Y/108/21/L

Stakers Farm North End Road Yapton BN18 0DU

Listed building consent for conversion of & alterations to existing barns to create 3 No. dwellings, erection of car barns & stores, a replacement pump house, demolition of barn, associated landscaping & parking (amendment to Y/106/19/L)

DRAWING TITLE
PROPOSED SITE LAYOUT

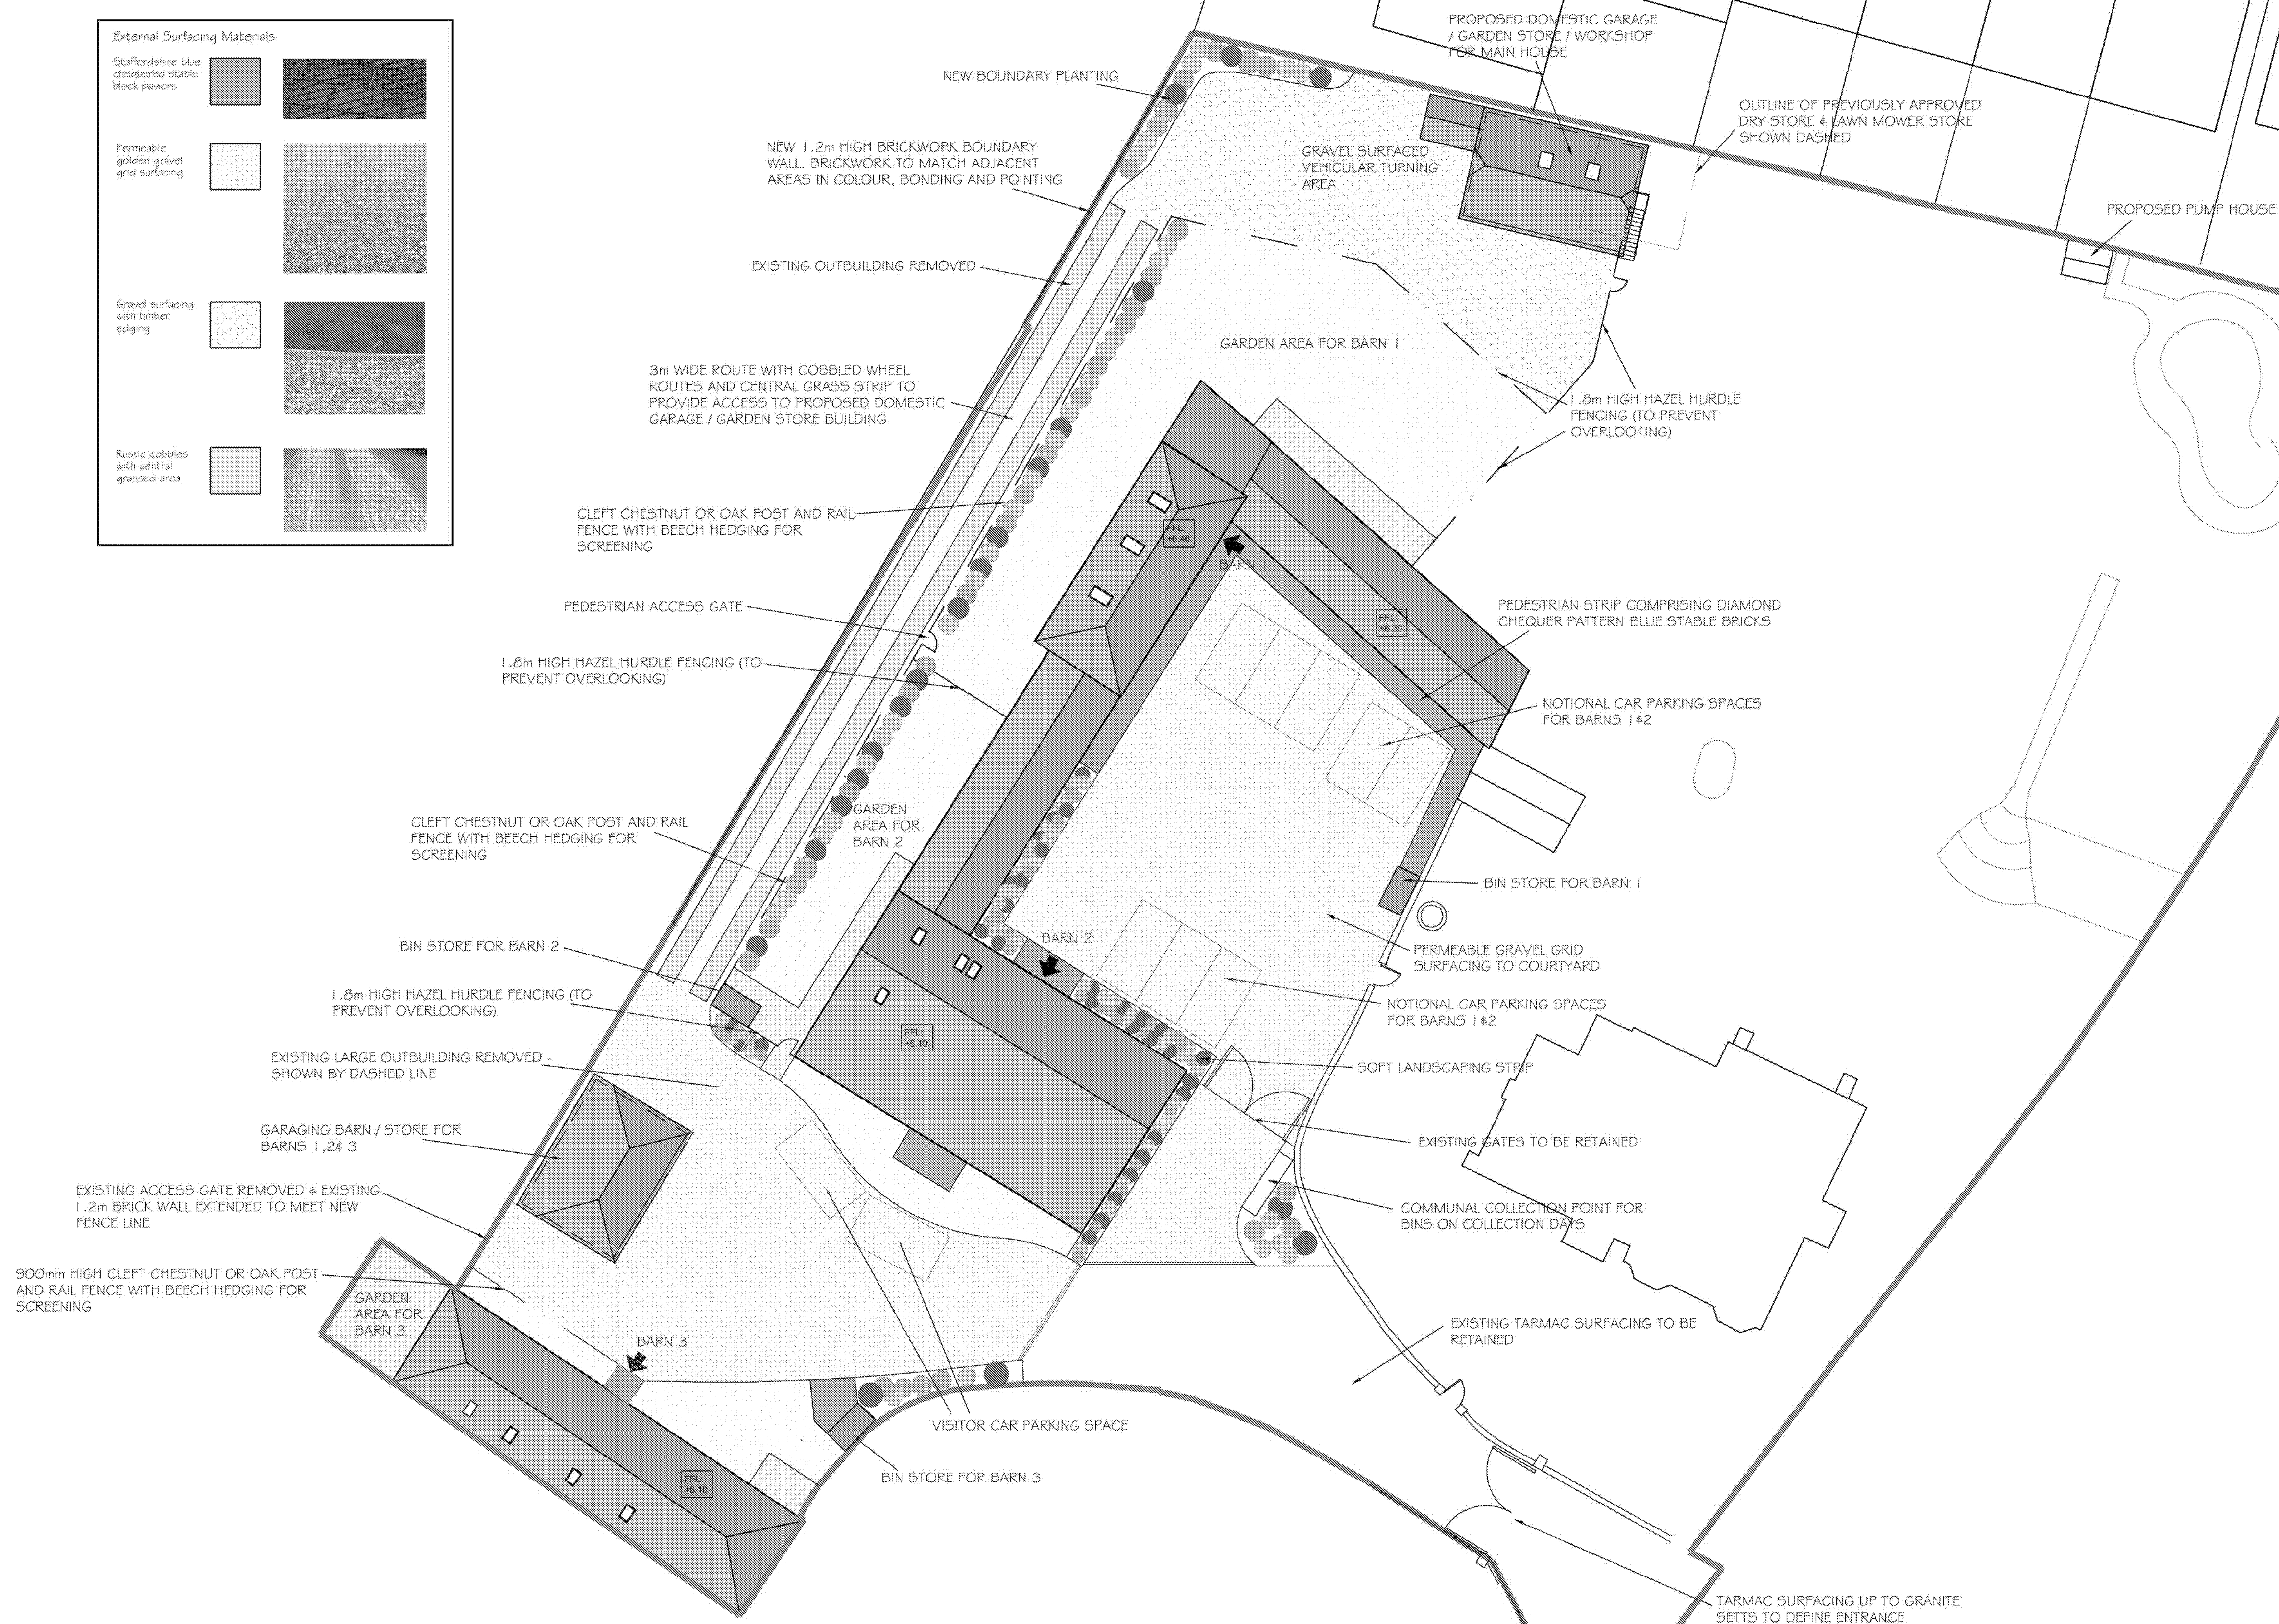
The use of brick pavements is of some concern, as this could introduce a sub-urban character into what should be a more rural one. From looking at the site plan it would appear that a significant area of the site would be paved in order to provide access to the parking courtyard. It is not clear why such a material was chosen, when something more in keeping would be more appropriate. However, if carefully chosen, it could be that such an approach would be acceptable. A sample of the material would be requested so as to fully assess the impact.

BARNs 1&2 PROPOSED SOUTH EAST ELEVATION
SHOWING SHUTTERS OPEN

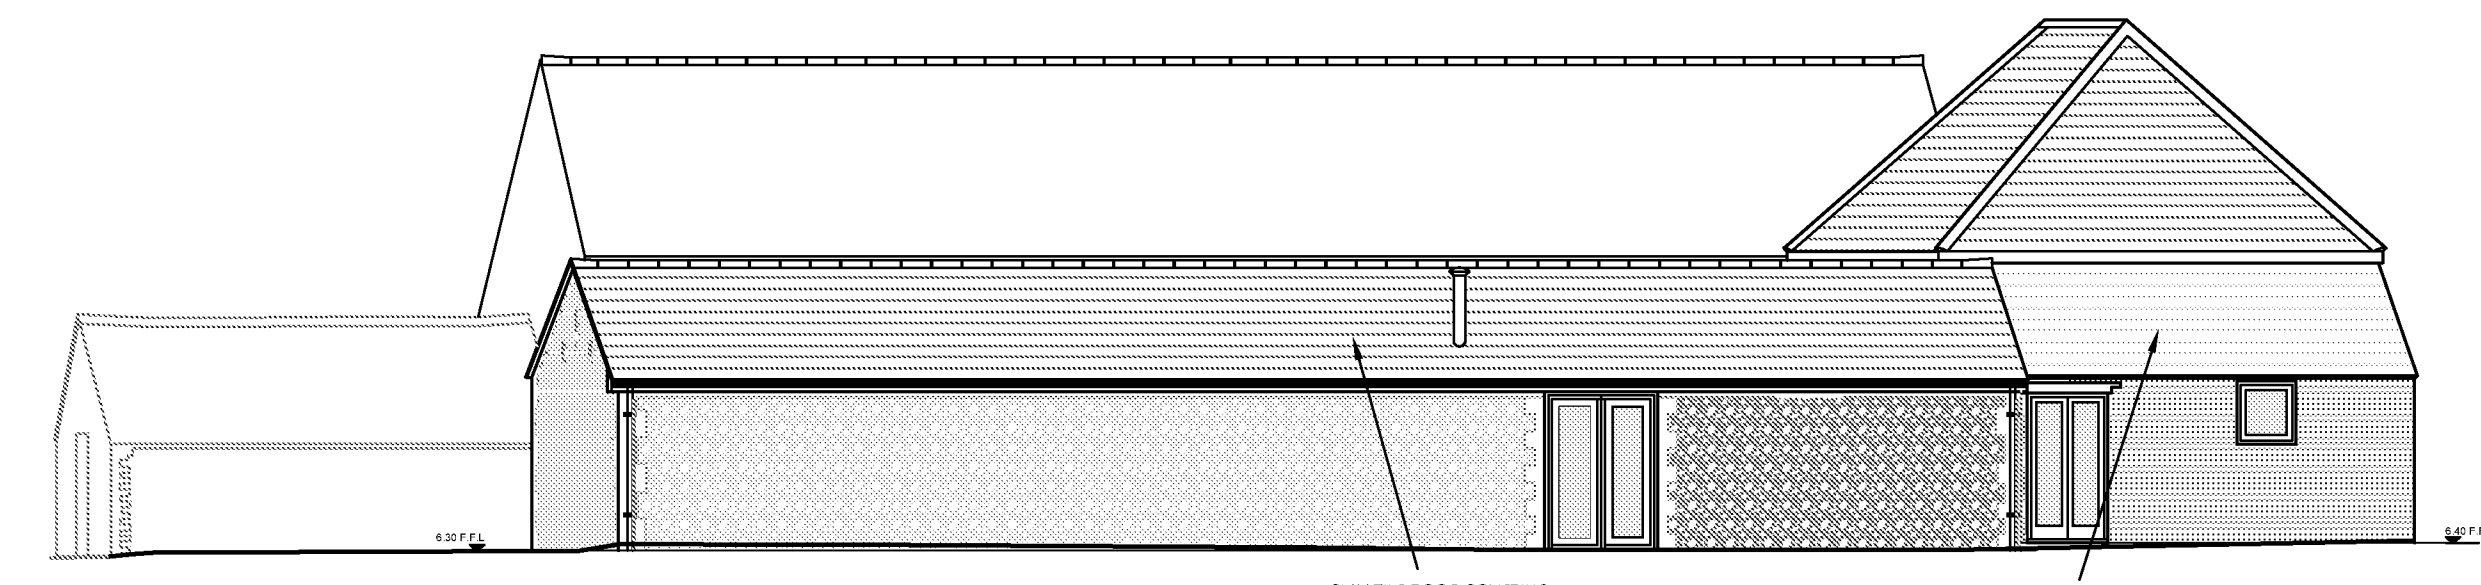
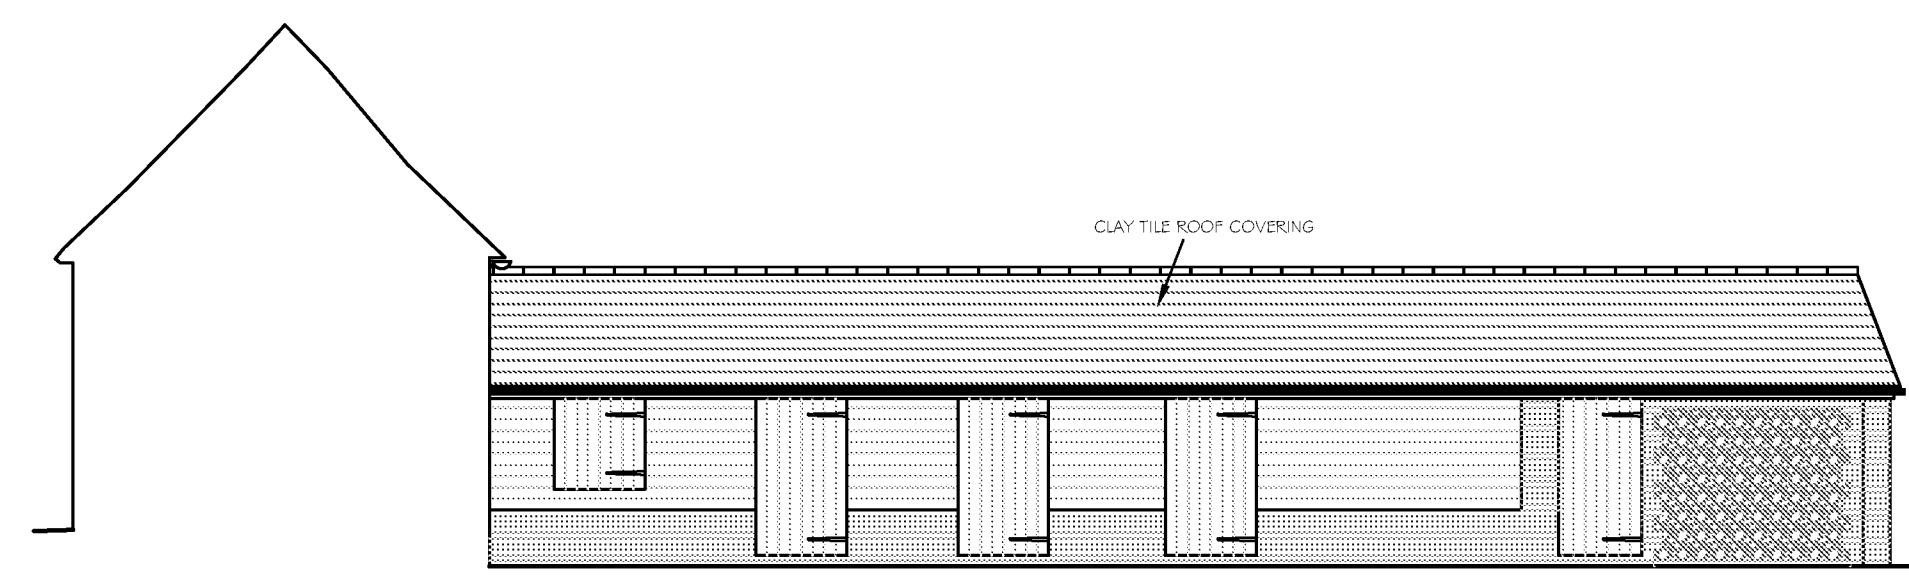
I am also concerned about the large window to be introduced to unit 2 on the South-East elevation, as well as the treatment of the existing opening for what will be bedroom three of the same unit. Further, it is not clear why the utility window of barn 2 is to be altered nor why a range of windows were chosen for the S.W courtyard elevation of barn one (when a more uniform appearance would be appropriate here). This requires clarification from the applicant, and it is suggested that more appropriate designs are prepared here.
